RE: **3500 Coors Blvd NW**
Conceptual Grading and Drainage Plan
Engineer's Stamp Date: 6/4/2018
Hydrology File: G11D038

Based on the submittal received 6/4/18, the Conceptual Grading and Drainage Plan cannot be approved until the following are corrected:

DATE
1/8/2019
SCALE
AS NOTED
Sheet
C1.1
of
1

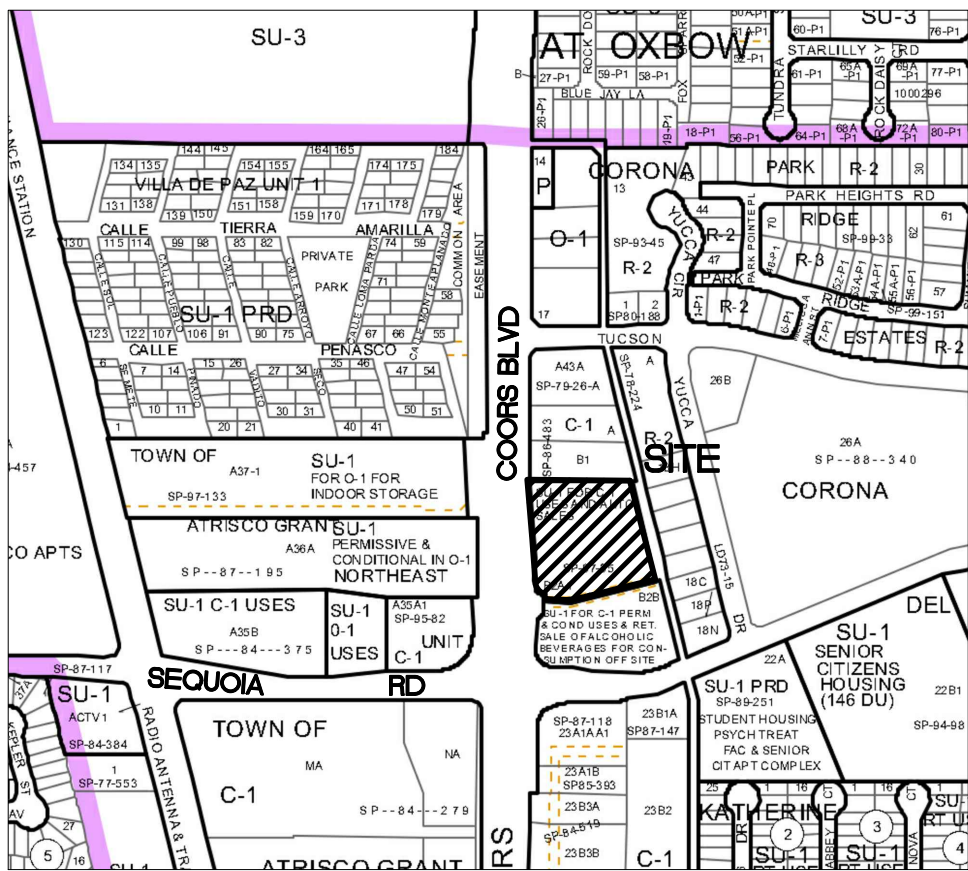
1. A digital (.pdf) submittal, emailed to PLNDRS@cabq.gov is required.
2. Management of the first flush volume needs to be described in greater detail. Please identify the ponding areas and size each one for the area draining to it. For undersized ponds or impervious areas not captured, quantify the first flush bypass volume and state on plans.

3. This site qualifies as redevelopment and is only required to retain runoff from the 80th percentile storm ($\text{Vol.} = 0.26'' \cdot \text{Imp. Area}$).

4. For trash enclosures serving food service developments, demonstrate *control of liquids from dumpster areas* per DPM Chapter 22.9.E, Table 1 by containing runoff from the dumpster area and discharging to the sanitary sewer. If this information is on the utility plan please provide it, or show on the grading plan.

5. Provide an existing drainage basins exhibit. The existing site appears to drain primarily to the alley, with only the west landscaping draining to Coors. This plan appears to show new basins A-1 and A-2 draining to Coors. Any increase in runoff to Coors will require written approval from NMDOT D3 Drainage that this project can proceed; please contact Tim Trujillo P.E (TimothyR.Trujillo@state.nm.us). Alternatively, provide ponding in the west landscaping or modify the drainage pattern to maintain runoff at current conditions.
